# CITY OF ALBUQUERQUE

September 16, 2014

**Re: Silver Avenue Townhomes Master Grading Plan  
Scott McGee's Engineer's Stamp 8-25-14 (K16D072A)**

C101

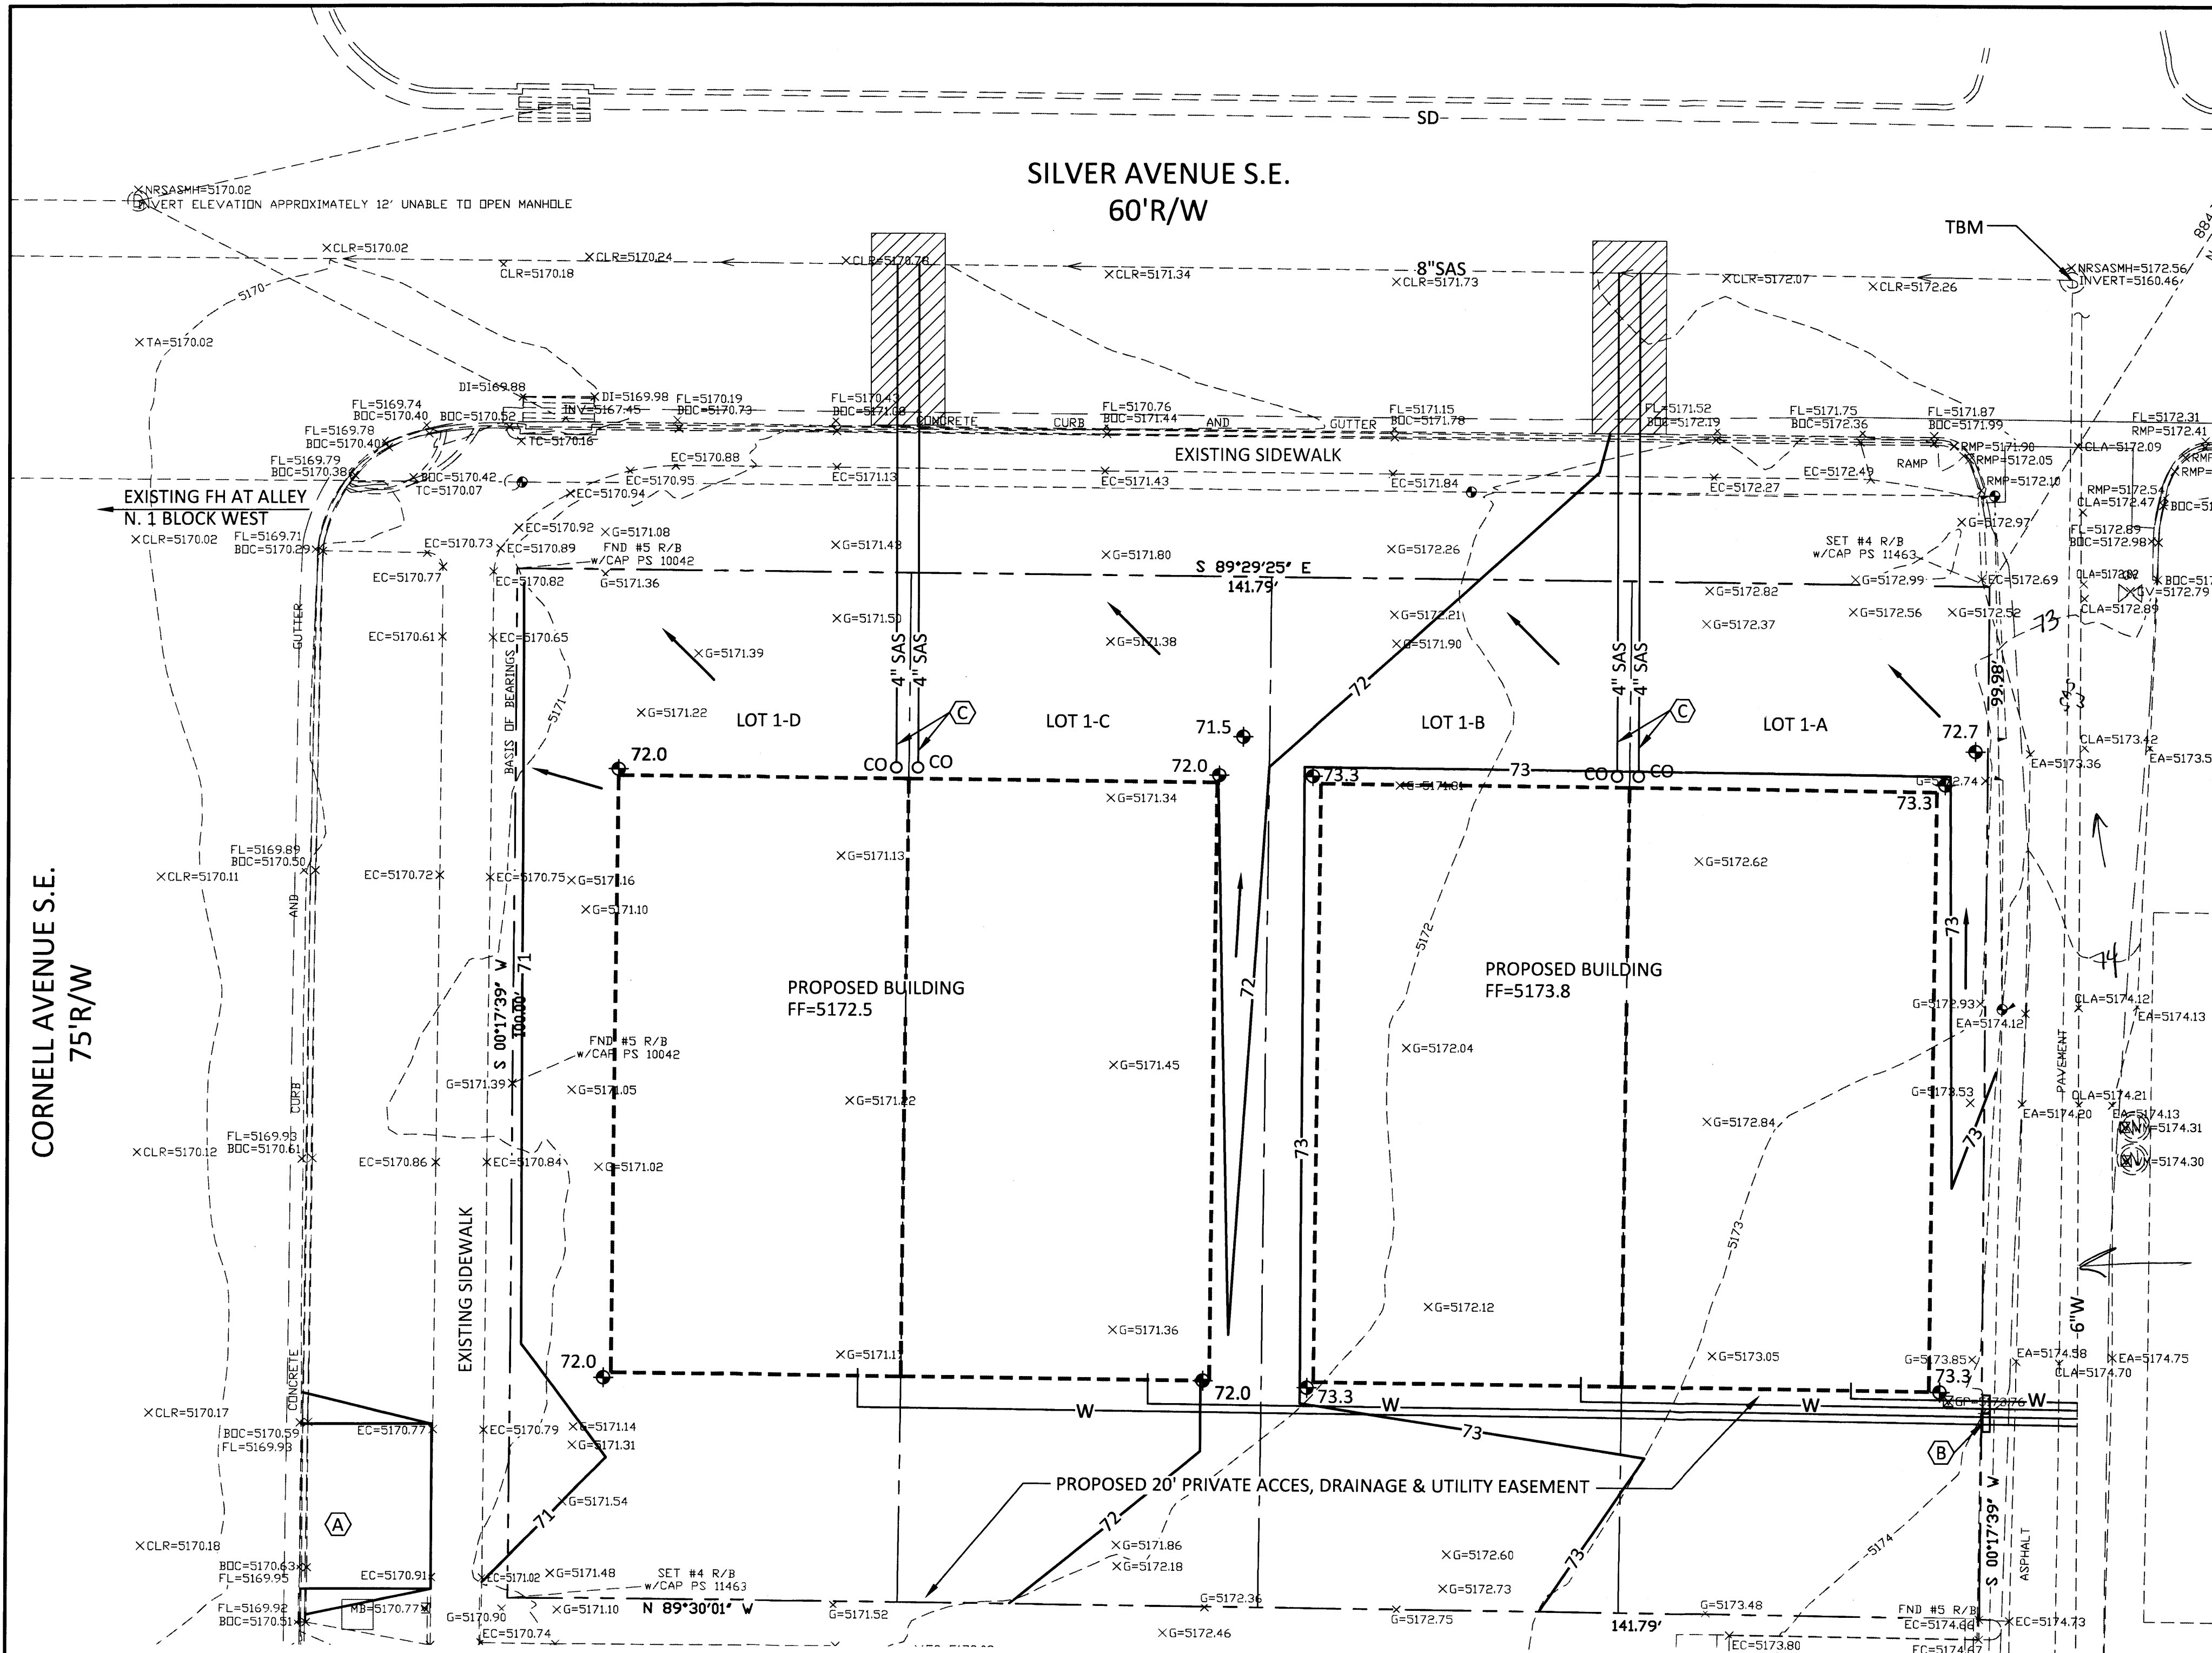
1. Retain the first flush. Per the City Drainage ordinance, the 90<sup>th</sup> Percentile Storm Event, which is 44 inches, is to be managed. Reduce 0.44 inch by the 0.1 inch for the initial impervious abstraction in Table A-6 of Section 22 of the DPM. Multiply the remaining 0.34 inch by your impervious area. This is the portion to retain. The front yards are a good location to retain the first flush on this site.
2. Discuss the existing offsite flows from the east that are crossing the alley and entering the property.
3. Confirm the proposed 73 contour on the east side of the property is tying into an existing 73 contour. It appears the existing contour is 74.
